Comments for Planning Application 24/00171/OUT

Application Number: 24/00171/OUT

Address: 24 High Street Cullompton Devon EX15 1AA

Proposal: Outline for the erection of a dwelling with some matters reserved and additional parking for No 24 High Street

Proposed Site Plan
scale 1:200

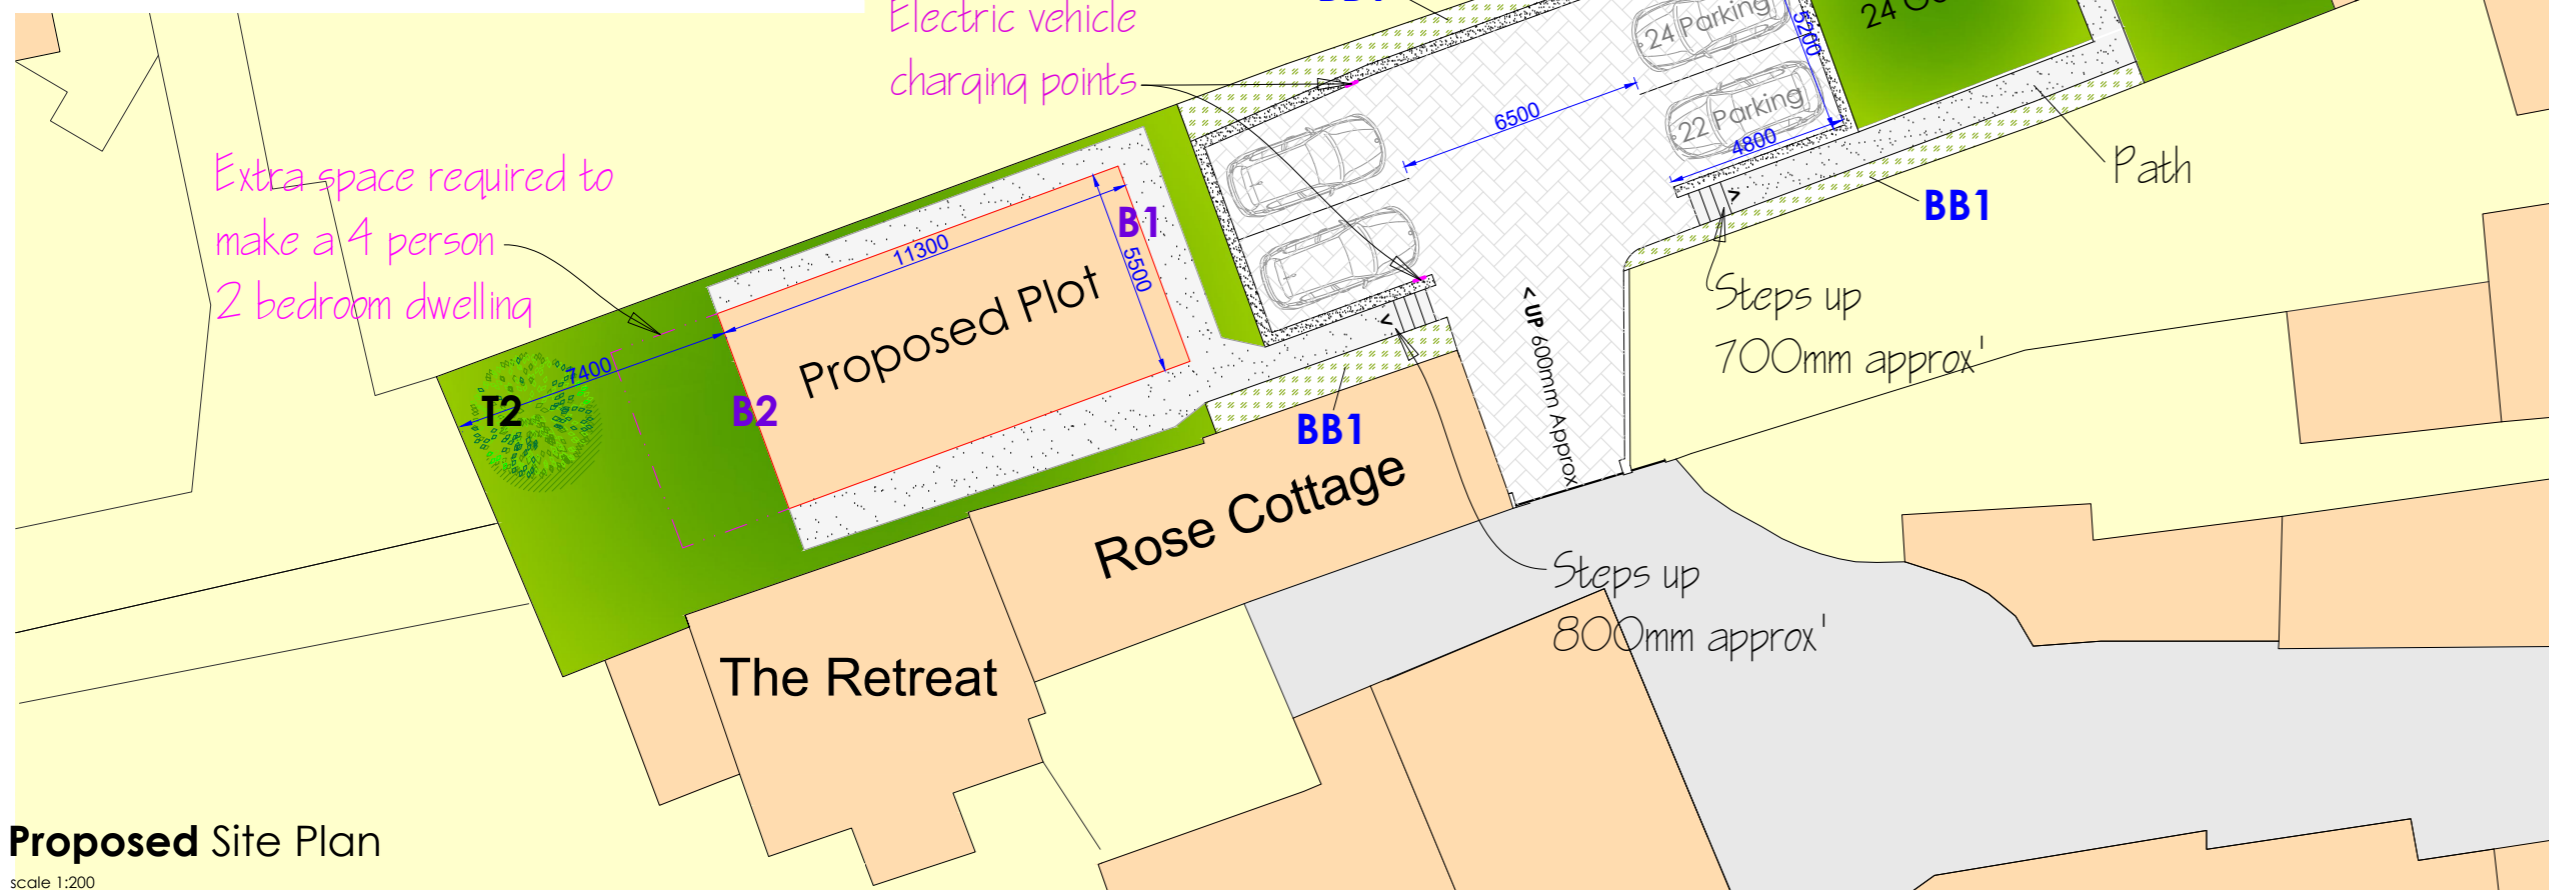
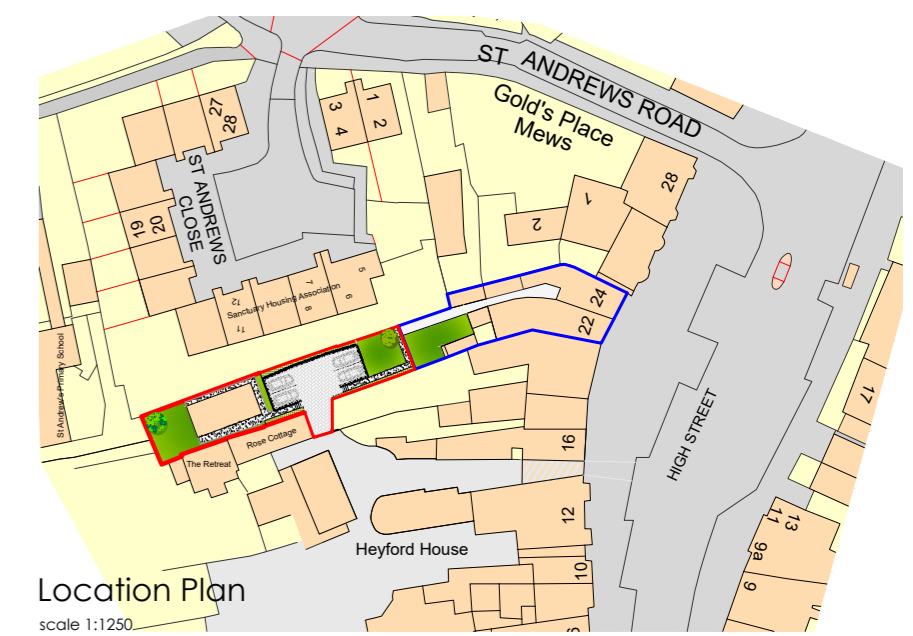
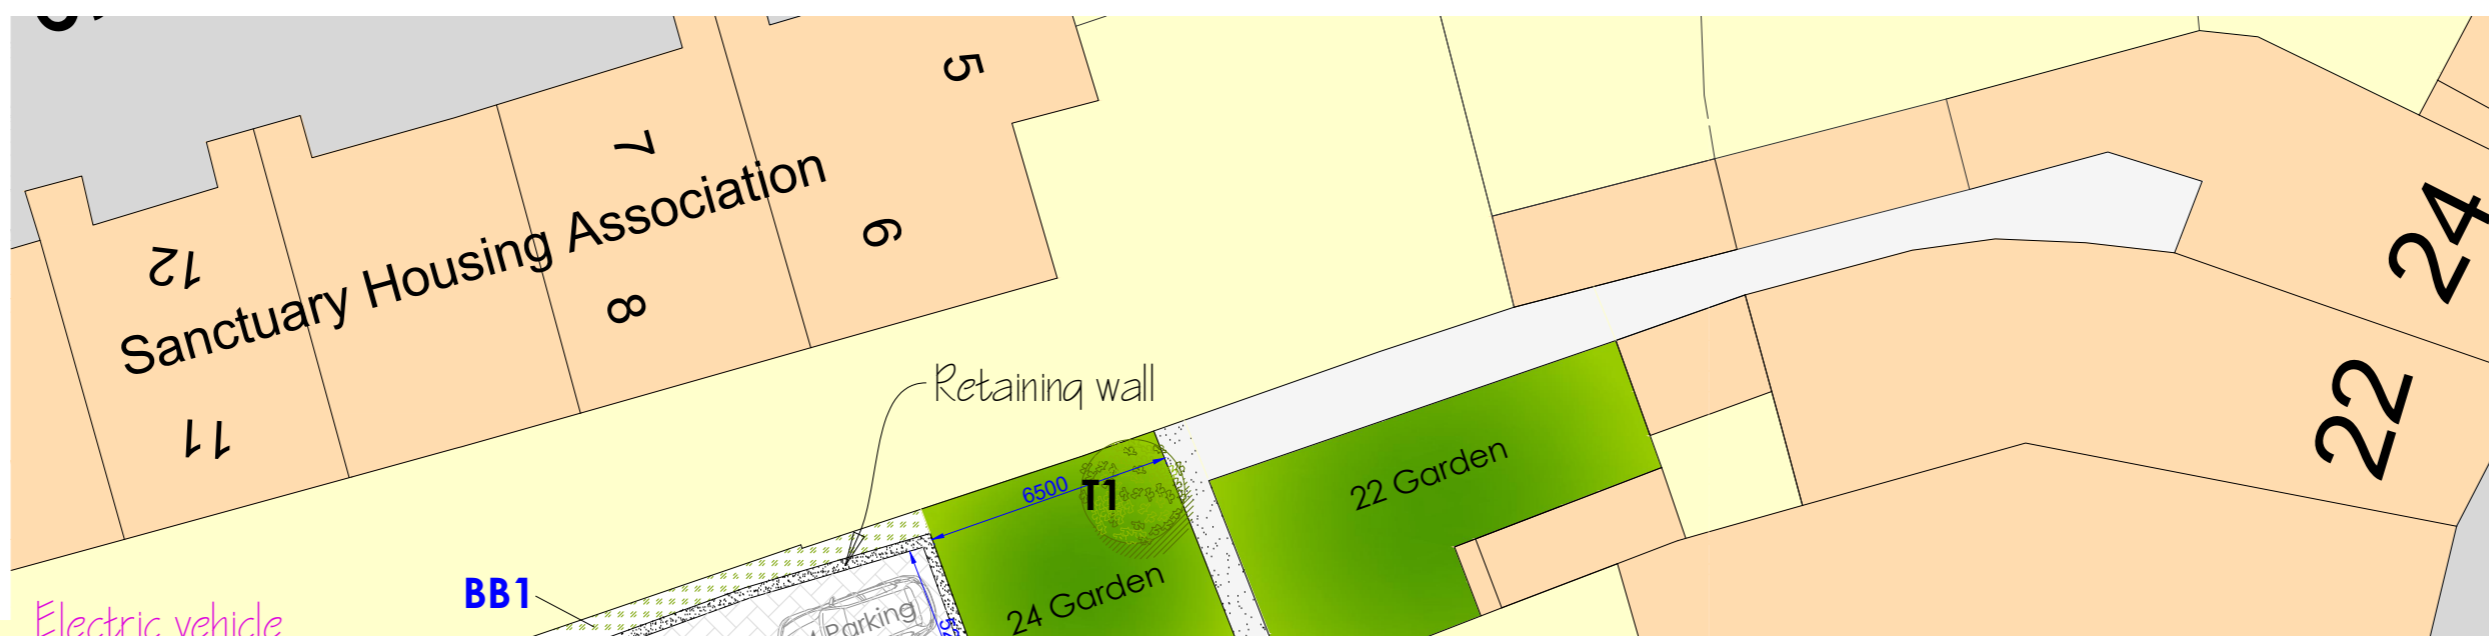
the proposed development would have to knock down the garage that is attached to my wall and would caused potential damage to my wall,also the footpath in front of the garage is shared by all our neighbourhood,such planning would put danger to all residents include young kids of my own.therefore we strongly opposed to this application!
